**DELEGATED DECISION FOR APPLICATION FOR CERTIFICATE OF  
LAWFUL DEVELOPMENT**

Reference no.: 2024/CL/91271/E

Site: 24, Scott Lane, Gomersal, Cleckheaton, BD19 4JY

Description: Certificate of lawfulness for proposed erection of  
single storey rear extension

Drg No 24/30/A Rev

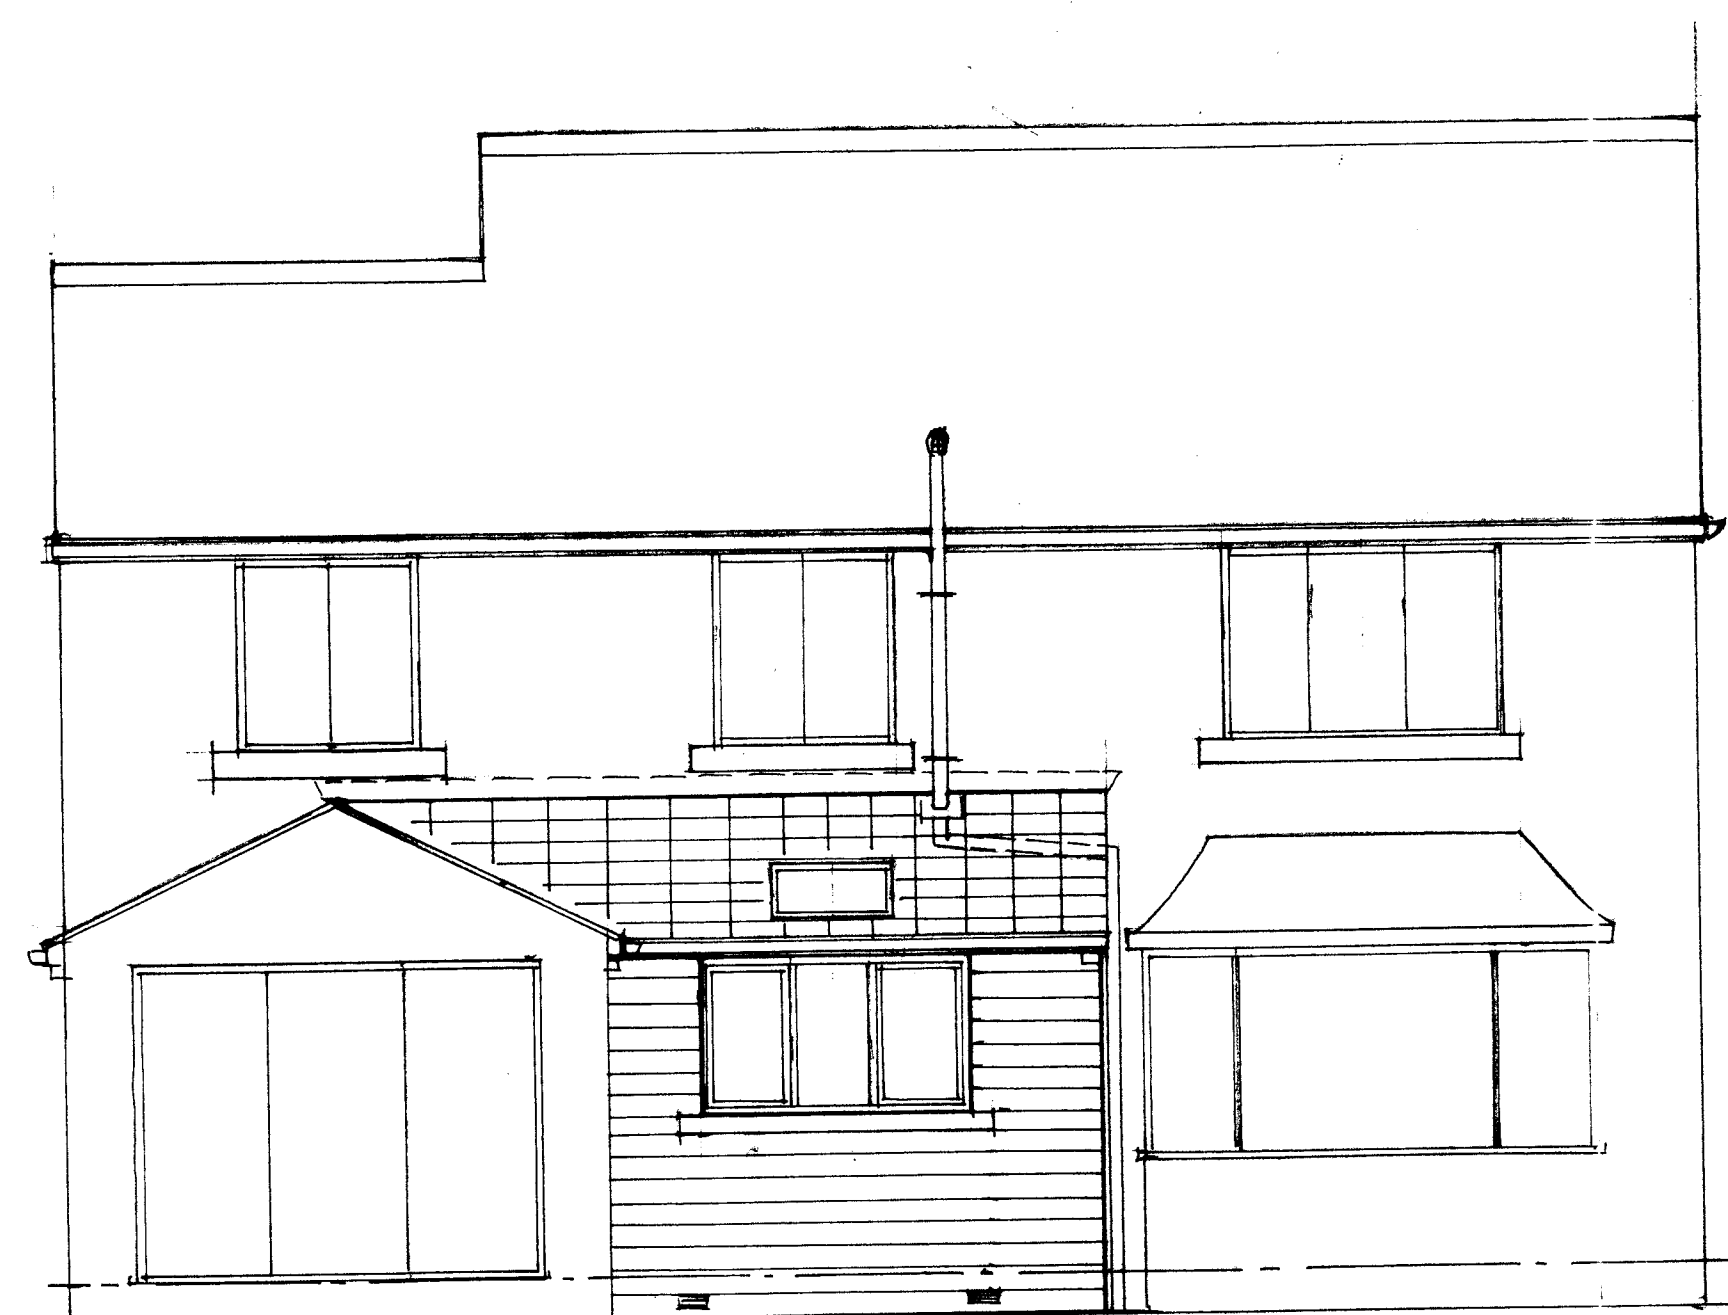
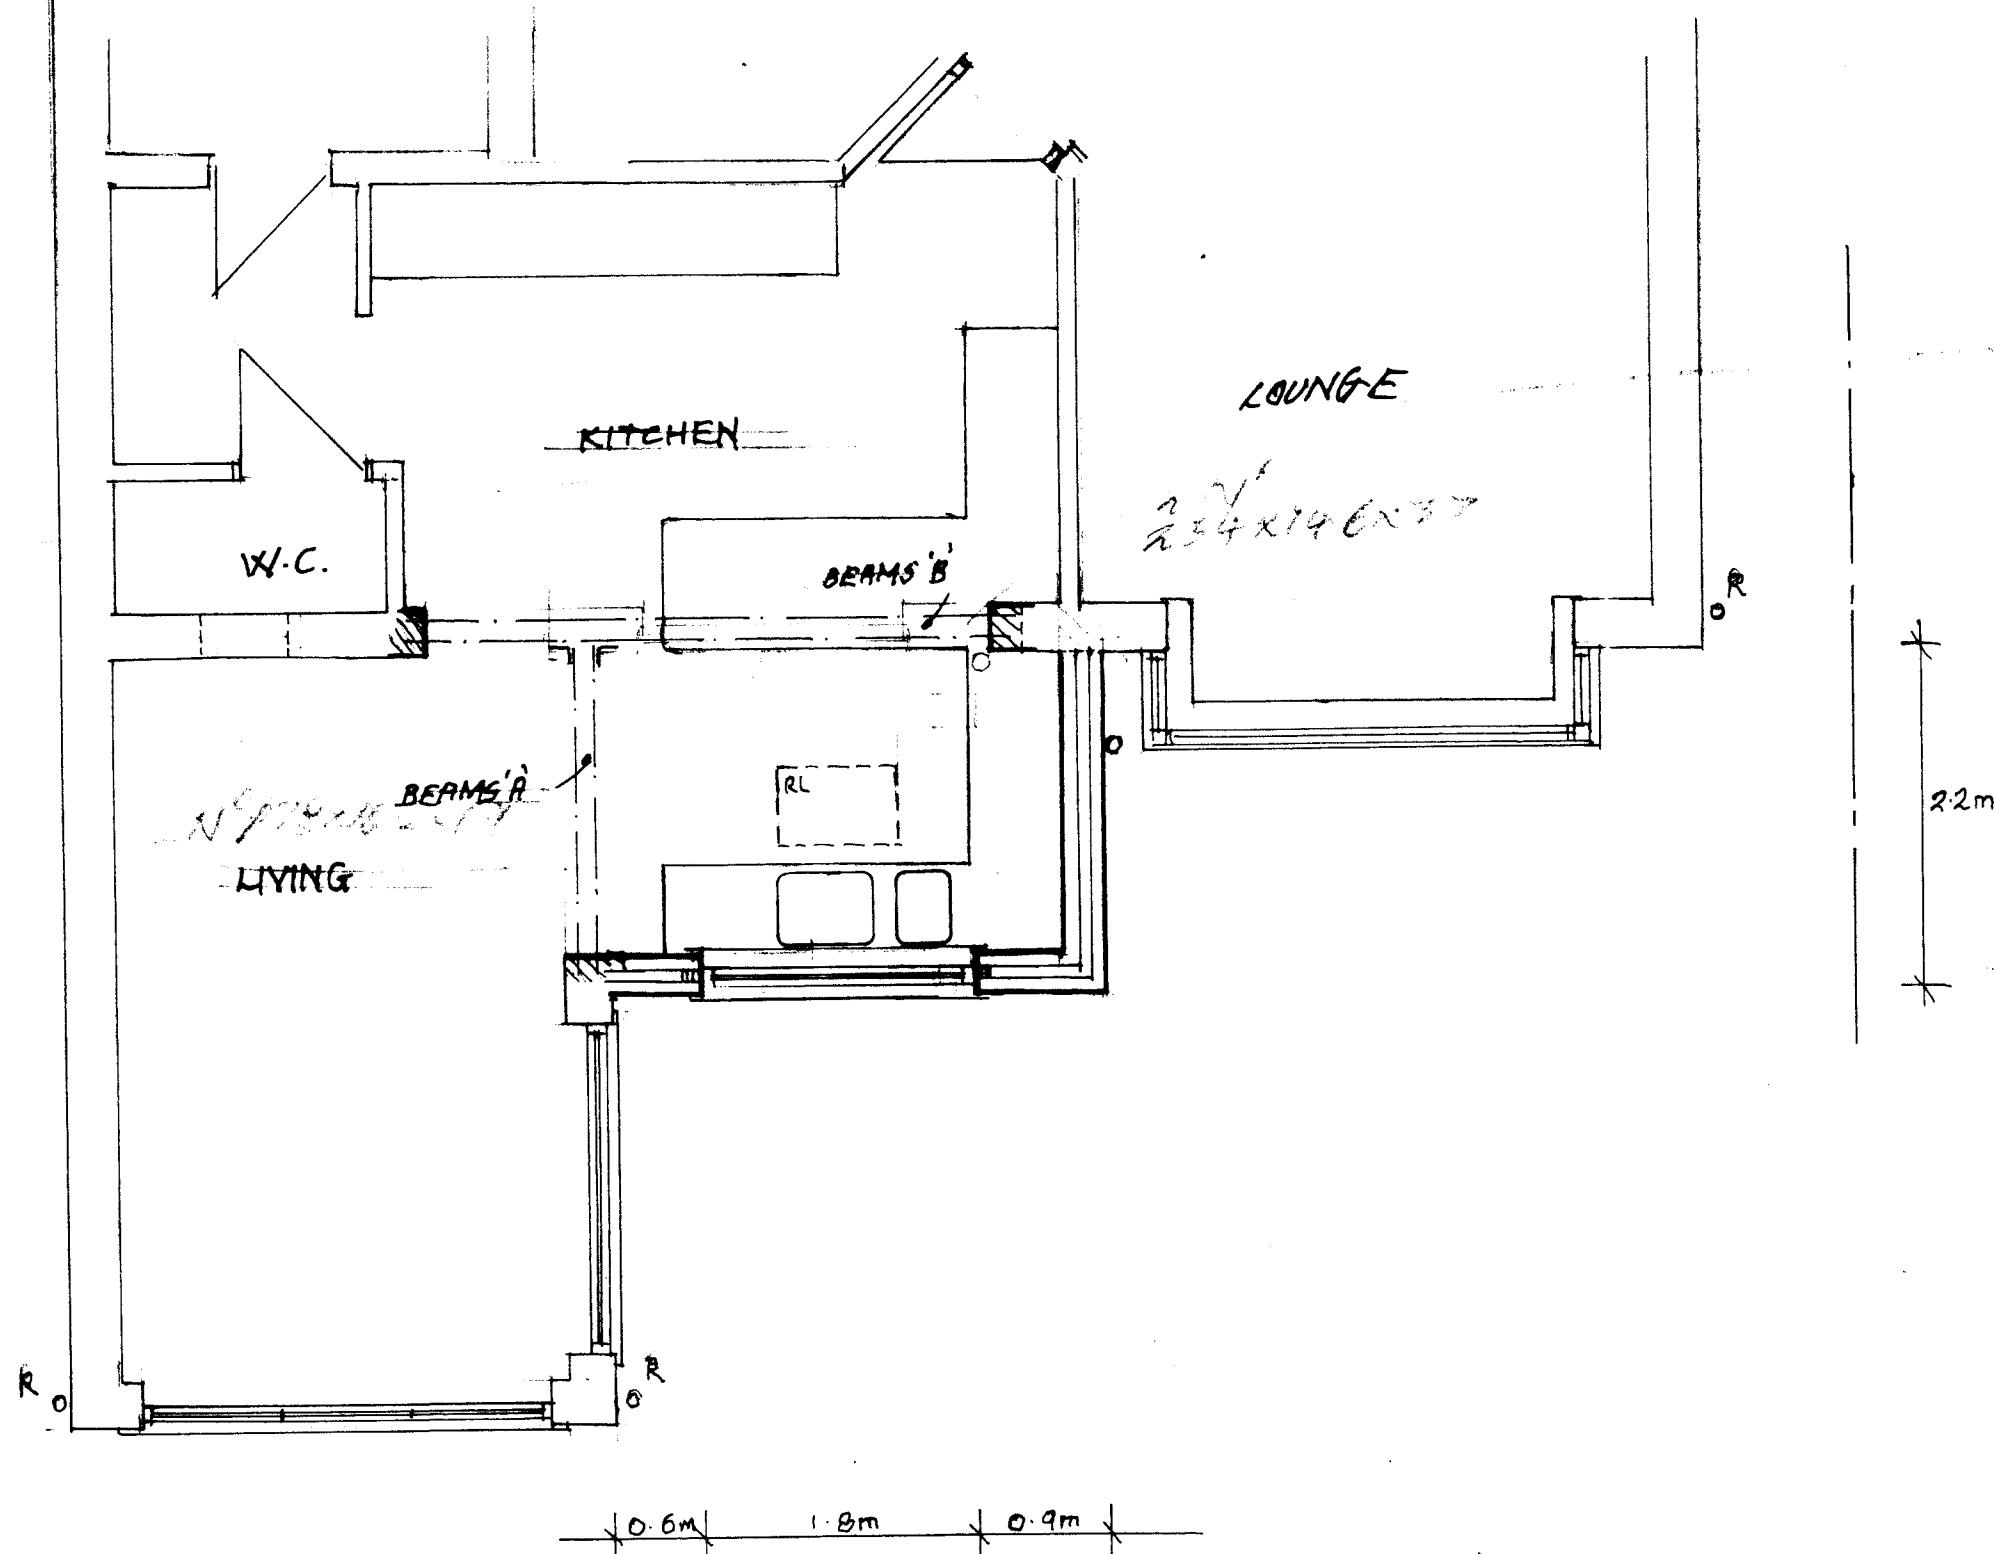
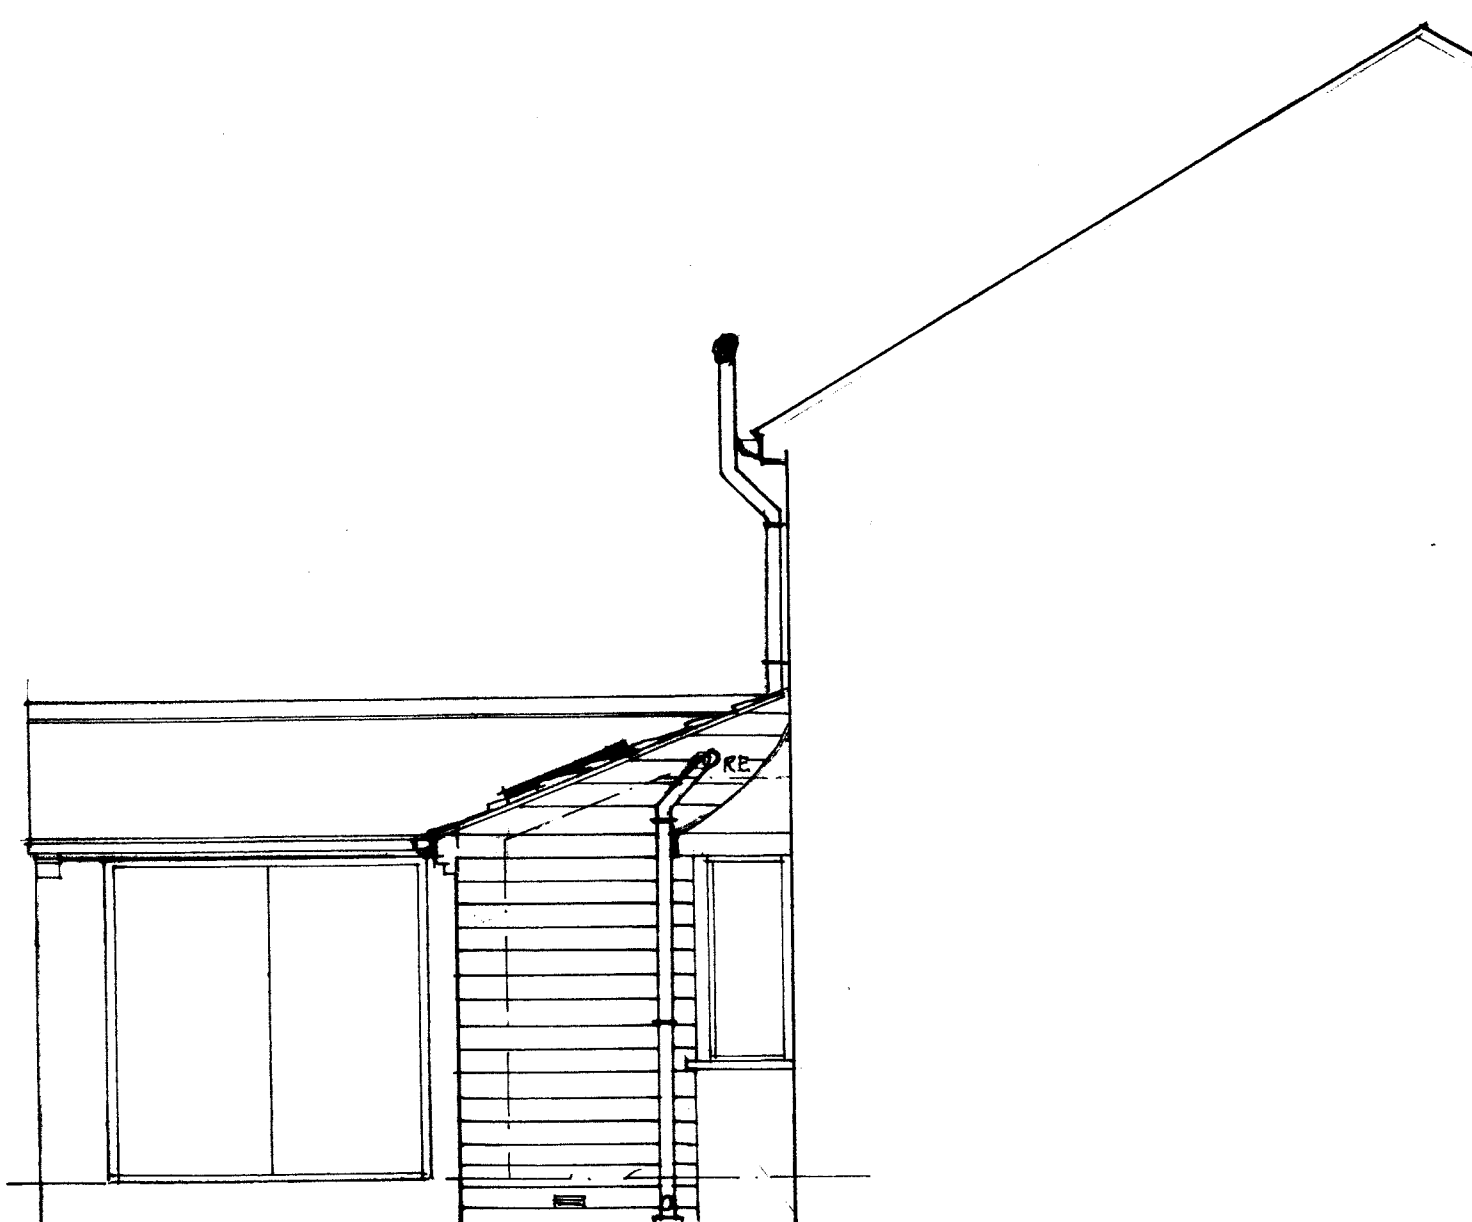
***Comment:*** *The property was extended pursuant to certificate of lawfulness application ref: 2004/92304 with a single storey rear projection. The proposed extension will adjoin onto the existing enlargement. Measuring from the submitted plans as part of this application, the existing enlargement projects more than 4 metres from the rear of the original dwellinghouse and is consequently contrary to paragraph (f) above but is within the tolerances of paragraph (g). Paragraph A.4(1) provides that any development granted by virtue of Class A is "where it exceeds the limits in paragraph A.1(f) but is allowed by paragraph A.1(g)" is permitted but only where subject to a prior approval. In this instance the proposed development, whilst in itself does not exceed 4 metres, is only allowed because of paragraph (g) because the existing enlargement does not exceed 8 metres. However, Article 3(1)&(2) grant the permission for the development but only subject to conditions which in this instance would include the condition A.4(1) requiring prior approval*

*because the proposed extension can only benefit from the limitations by being allowed by paragraph (g). The extension would therefore be subject to prior approval which has not been granted.*

**Comment:** *The proposed works would result in an alteration to a soil and vent pipe.*

The proposed rear extension would not benefit from a general planning permission granted under Article 3(1) and Schedule 2, Part 1, Class A of the Town and Country Planning (General Permitted Development) (England) Order 2015 (as amended) because the proposed extension together with the adjoining existing extension to the dwellinghouse would exceed the limits set out in sub-paragraph A.1(f) but whilst allowed by sub-paragraph A.1(g) it is only subject to prior approval which has not been granted thus contrary to condition A.4(1) of Class A.
